From: Nicola Moore <Nicola.Moore@arun.gov.uk> **On Behalf Of** Planning
Sent: 26 November 2019 11:23
To: Planning.Responses <Planning.Responses@arun.gov.uk>
Subject: FW: Planning Application AW/250/19/HH 19 Kingsway, Craigweil, Aldwick

Ref: AW/250/19/HH

We note that the above planning application is to increase the width of the gateway to the property. The application does not appear to contain a detailed plan showing the proposed alteration. Therefore, it is impossible to determine the exact nature of the proposal.

Proposed

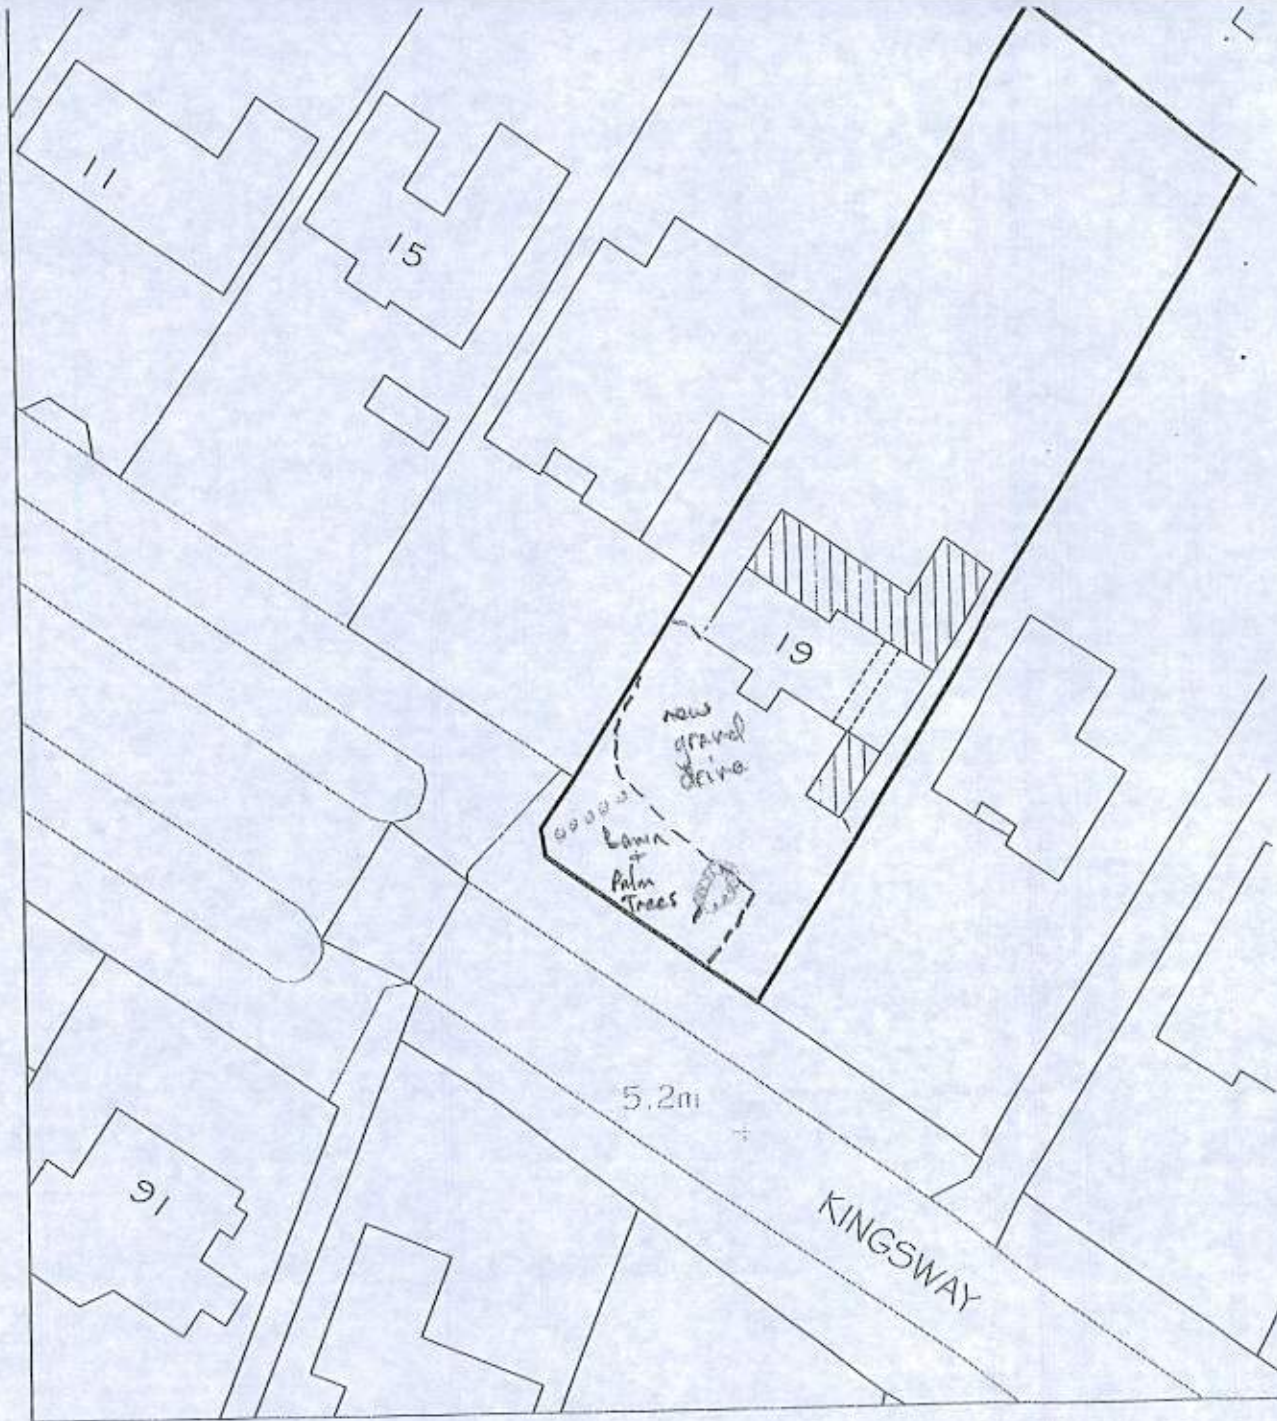
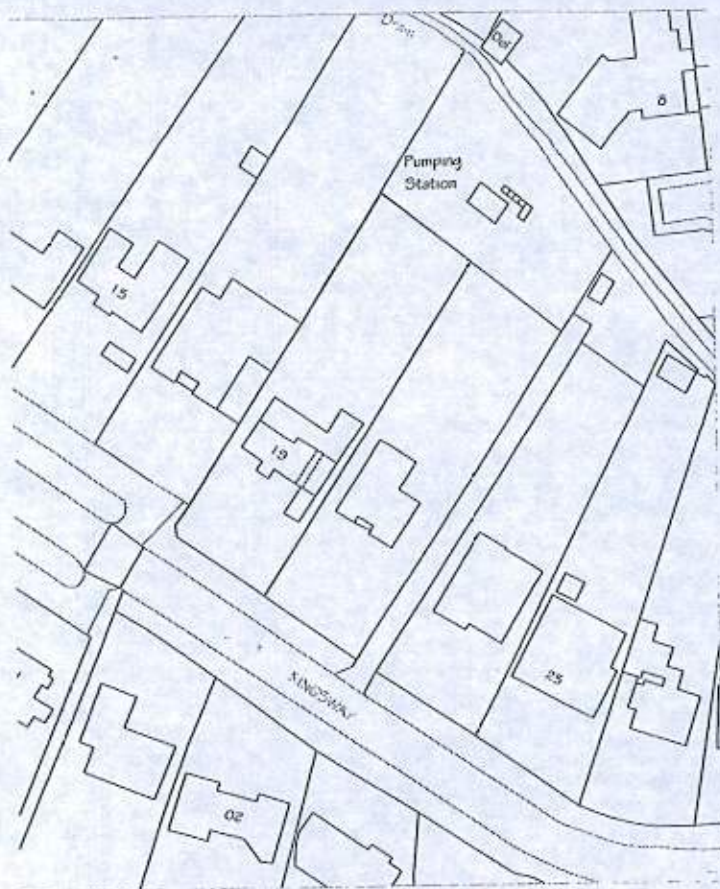
The verge at the front of 19 Kingsway is owned by Craigweil Private Estate Ltd. on behalf of the estate residents. There is a tarmac cross-over which traverses the verge to give vehicular access to 19 Kingsway. This cannot be altered in size, construction or appearance without the express consent of CPEL.

I have measured the width of the opening of the existing gateway. It is already 2.5mtrs - the width requested by the applicants. The width of the tarmac cross-over at this point where it enters the property is also 2.5mtrs.

The dropped kerb is 3.65mtrs wide. The cross-over increases in width as it approaches the kerb to facilitate easier access onto Kingsway. The cross-over is also 3.65mtrs wide where it joins the carriageway. These measurements differ from those provided in the application.

- 1 - Lack of clear and accurate information regarding the exact nature of the application,
- 2 - It would appear that the application is inherently flawed as the requested gate-width is identical to the current width.
- 3 - Possibility that an altered gateway could be wider than the cross-over, thereby allowing vehicles to drive on the grass to enter the property.
